Burwood Council
2 Conder St, Burwood 2134
PO Box 240 Burwood NSW 1805

Our Ref.: 22/15237
29 April 2022

**BURWOOD COUNCIL SUBMISSION – SSI 22765520 – SYDNEY METRO WEST – RAIL
INFRASTRUCTURE, STATIONS, PRECINCTS AND OPERATIONS**

**Figure 11-14 Representative viewpoints – Burwood North Station**

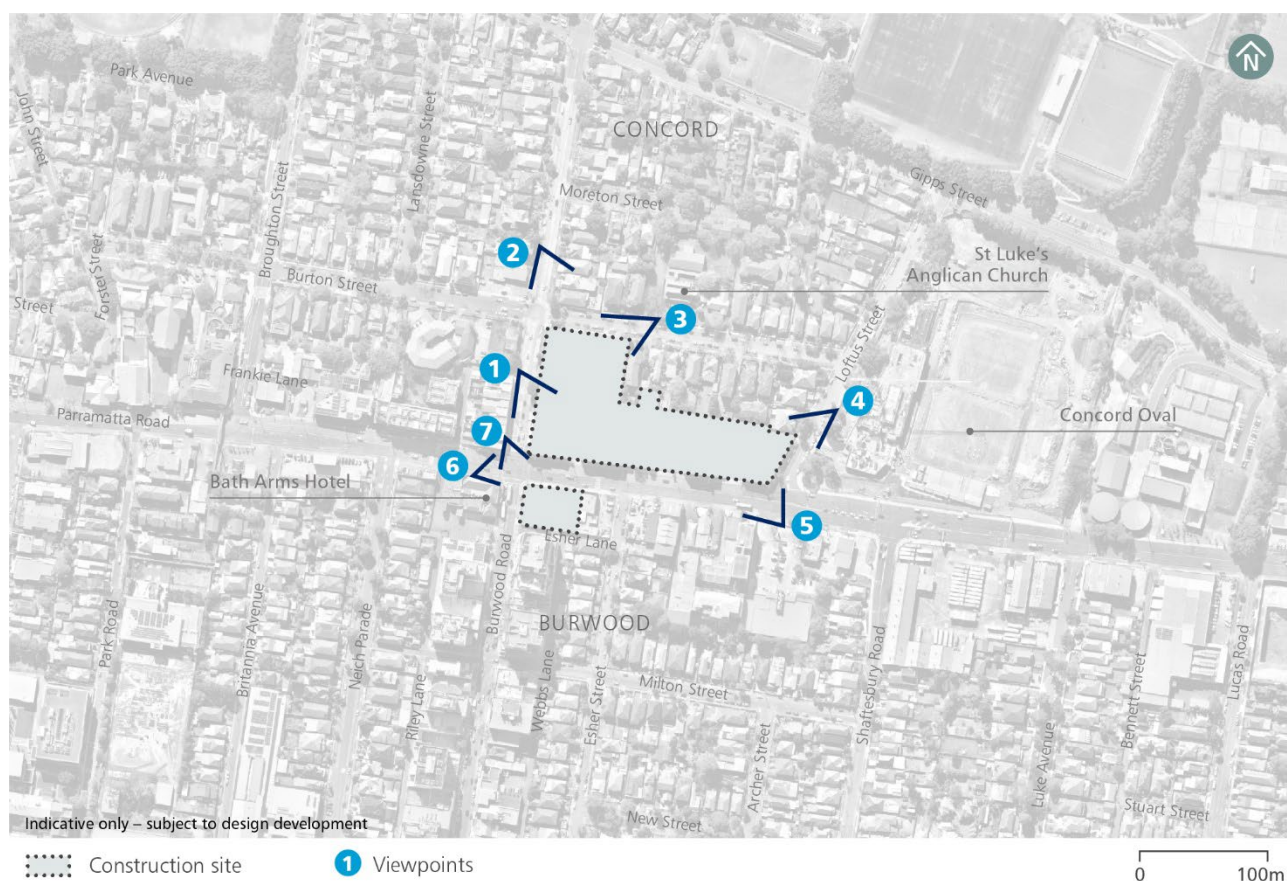
Page	Comment	Recommendation
40, Figure 11-14	<p>No representative viewpoints have been identified to inform the daytime visual impact assessment on the southern side of the precinct.</p> <p>Council requests that consideration be given to including an additional representative viewpoint looking south directly to the mixed use development at 8 Burwood Road, Burwood to the south. This viewpoint could align with the eastern boundary of the southern station entry site.</p>	<p>That Figure 11-14 and its associated text be updated to include an additional representative viewpoint referencing the southern station precinct.</p>
41	<p>As outlined above, the impacts of the shadows of the southern station building on the mixed use development to the south at 8 Burwood Road, Burwood have not been resolved.</p> <p>Council requests further information be included regarding design options and background analysis undertaken by Sydney Metro with respect to the design of the proposed building in order to allow Council to undertake an informed assessment.</p>	<p>Provide additional details as to the proposed height and design of the southern station building so that Council is able to undertake an assessment of its impact and provide an informed response.</p>
